RE: SUBMISSION TO SSD-79276958 FOR RESIDENTIAL FLAT BUILDING WITH INFILL AFFORDABLE HOUSING

Thank you for the opportunity to comment on State Significant Development (SSD) application (SSD-79276958) for demolition of existing structures, tree removal and construction of a residential flat building, including infill affordable housing, at 59 – 63 Trafalgar Avenue and 1A & 1B Valley Road, Lindfield.

Attachment 1 - Ku-ring-gai Council's Response to Applicant's RtS

Level 8 C.O.S terrace 1:150 @ A1

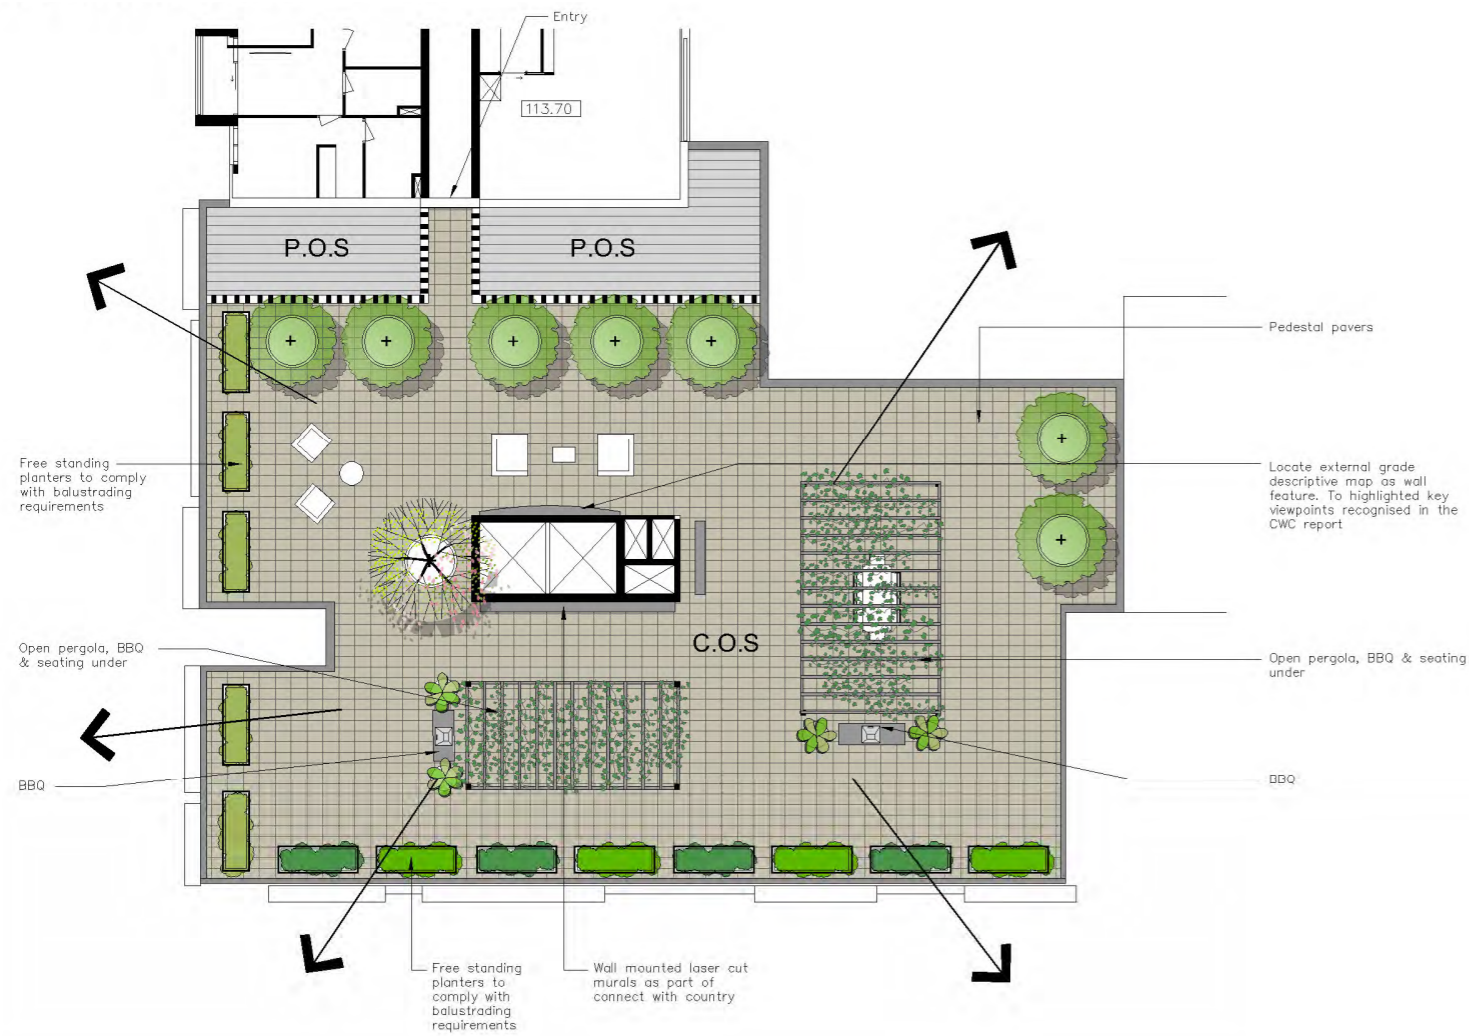
All proposed communal open spaces located above structural elements rely on the use of removable pots for trees, screening shrubs, and feature planting. This approach is inconsistent with the requirements of Part 4P of the ADG. Instead, planting should be provided in integrated systems that are built-in, properly drained, irrigated, and designed to support long-term plant health and visual quality.

The proposal only provides removable potted plants above structures, which are not supported. Potted planting systems are vulnerable to extreme weather conditions and irrigation failure and do not align with the requirements of Part 4P of the ADG.

To maintain visual privacy and enhance residential amenity through effective screening and layered planting, built-in planters shall be provided at the

interfaces between POS and COS. This is required for the terraces of Units 1.07, 1.08, 1.09, 1.10, 1.11, 1.12, 1.13, 1.14, 1.21, 1.22, 1.23, 8.01, and 8.04 to ensure an adequate level of amenity and privacy, consistent with ADG requirements. These interface zones shall incorporate small-leaved screening shrubs to provide visual privacy, wind attenuation, and an improved level of amenity for users of both private terraces and communal open spaces. • Edges on roof COS: Built-in planters, designed in accordance with the soil depth and volume requirements of ADG Table 5 (Part 4P), shall be provided along the edges of roof-level communal open spaces. These planters should incorporate cascading species and small-leaved screening shrubs to soften the built form, enhance the streetscape, improve wind mitigation, and provide durable, year-round greenery. This requirement applies to the following locations: • Podium Level 4 along Trafalgar Avenue; • Podium Level 5 along Trafalgar Avenue and the northern façade; • Podium Level 7 along the southern façade; and • Podium Level 8. • Plant Selection: The planting design should include species suited to wind exposure, drought conditions, and variable solar exposure. Seasonal variation should be considered, and allowance made for species rotation as part of a detailed maintenance regime. Planting above structures shall include large built in planters with trees known to perform well in a restricted built environment to provide amenity to users and to surrounding sites. • Planting Details and Maintenance: The submitted landscape plans do not adequately demonstrate planting details, soil volume provisions, or maintenance specifications. In addition, maintenance access to planting areas above structures have not been clearly addressed. • Irrigation and Access: The design should incorporate automated irrigation systems and ensure adequate access for ongoing maintenance of all planted areas above structures. TREE REMOVAL and IMPACTS Part 40 ADG & Part 13 Tree and Vegetation Preservation KDCP 1. The removal of the following trees is not supported: • T44 (<i>Melaleuca quinquinervia</i>); and • T45 (<i>Podocarpus elatus</i>). 2. The Arboricultural Impact Assessment (AIA) fails to accurately assess impacts on retained trees: The AIA makes recommendations for various impacted retained trees e.g. <i>“it will need to be demonstrated that the proposed hard surfacing can be constructed without impacting significant roots in the TPZ.”</i> The above has not been demonstrated either in the arboricultural assessment or elsewhere in the documentation provided. Therefore, retention of the trees as indicated in the AIA remains uncertain.
